City of Portland, Maine - Building or Use Permit

Permit No: 04-0551	Date Applied For: 05/07/2004	CBL: 142 B015001
------------------------------	--	----------------------------

Location of Construction: 985 Forest Ave	Owner Name: Wojcik Joseph B Jr	Owner Address: 2 Juniper Ln	Phone:
Business Name:	Contractor Name: Burr Signs	Contractor Address: 10 Buttonwood St. So. Portland	Phone (207) 799-1183
Lessee/Buyer's Name	Phone:	Permit Type: Signs - Permanent

Dog Wash / Add a 4' x4' wall sign

DETAIL VIEW
PORTLAND DOG WASH
981 FOREST AVE.

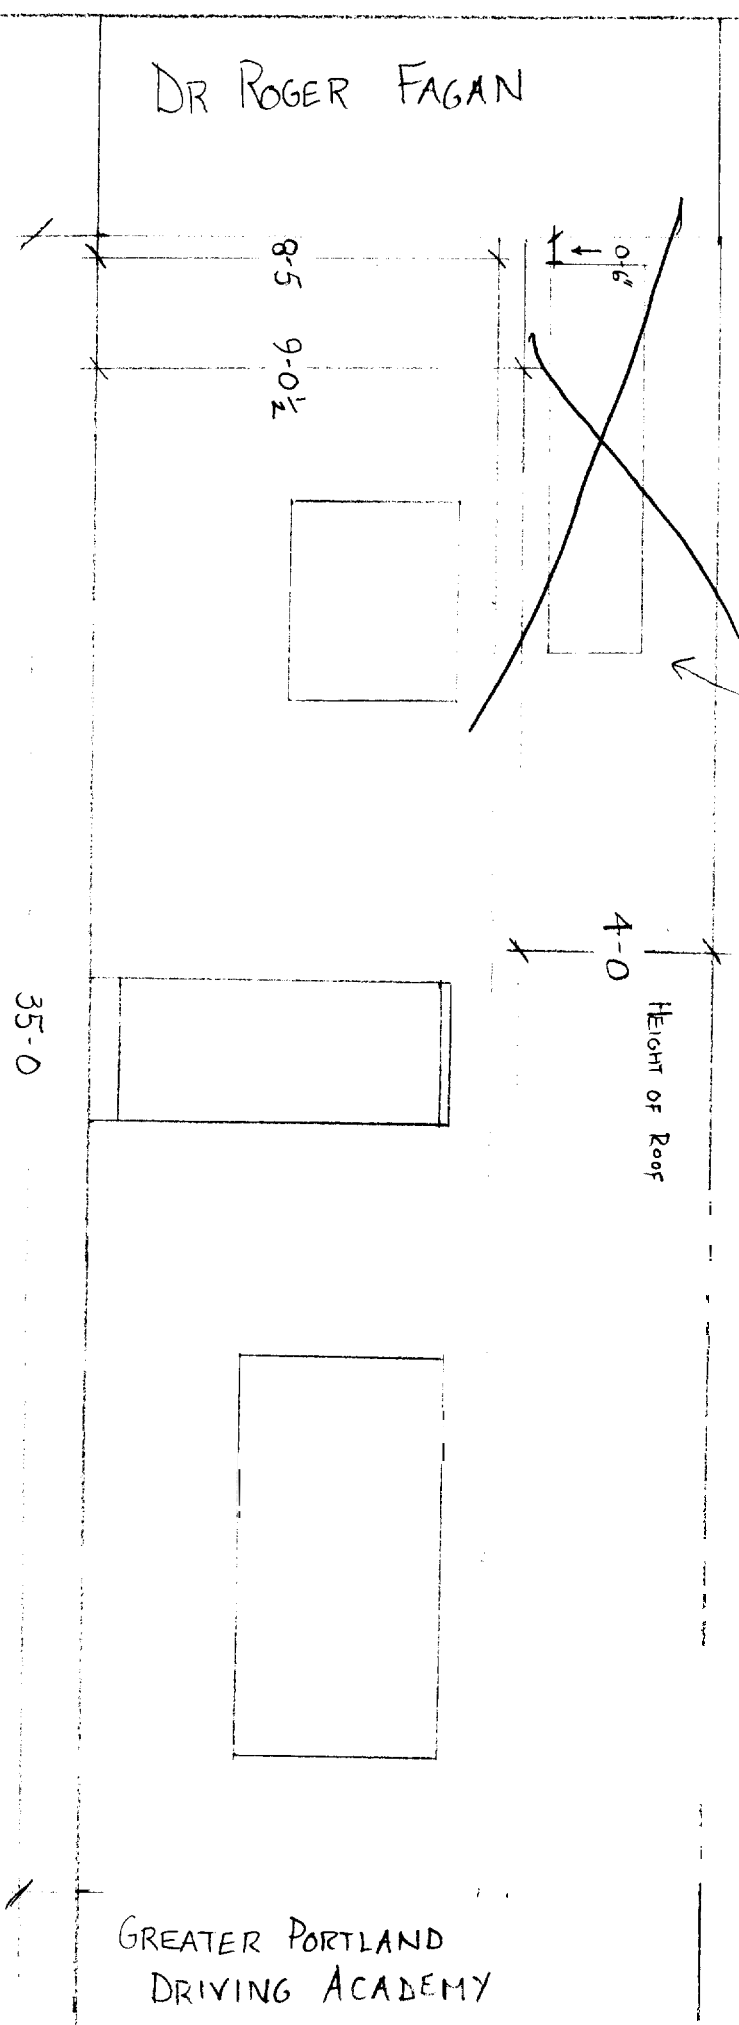
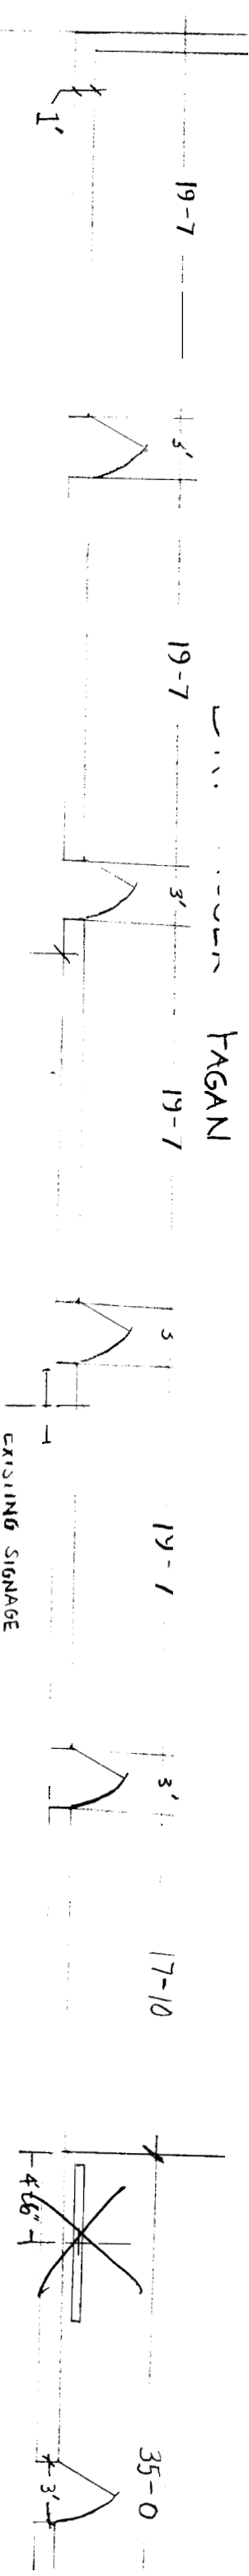
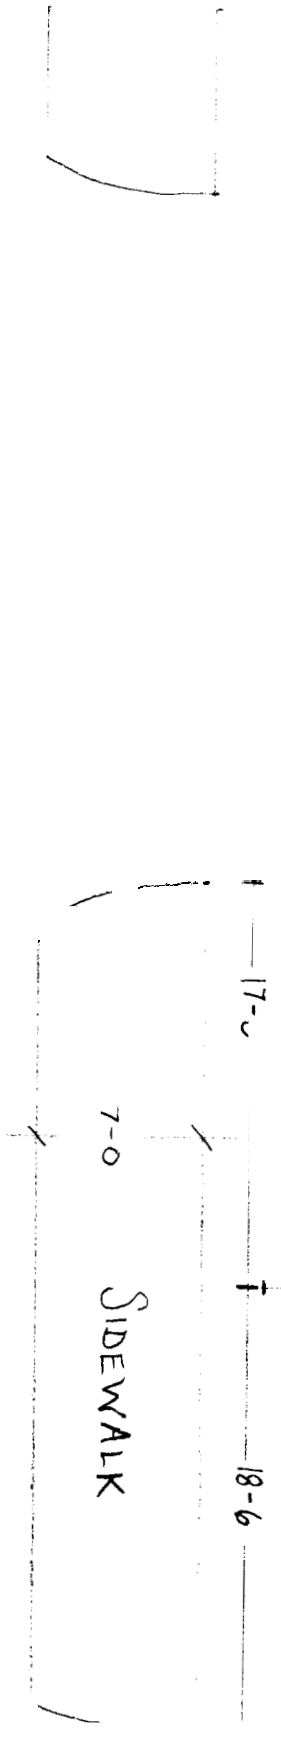
Note: 5/28/04 roof top signs are prohibited under section #14-369.5(a) - Spoke to Randy - He will discuss with his client **Ok to Issue:**

6/17/04 received revised plans showing there will now be a 4' x4' wall sign

1) This permit is being approved on the basis of revised plans submitted and recieved on 6/17/04. Any deviations shall require a separate approval before starting that work. It is understood that the new 4' x 4' sign is a wall sign and not a roof sign.
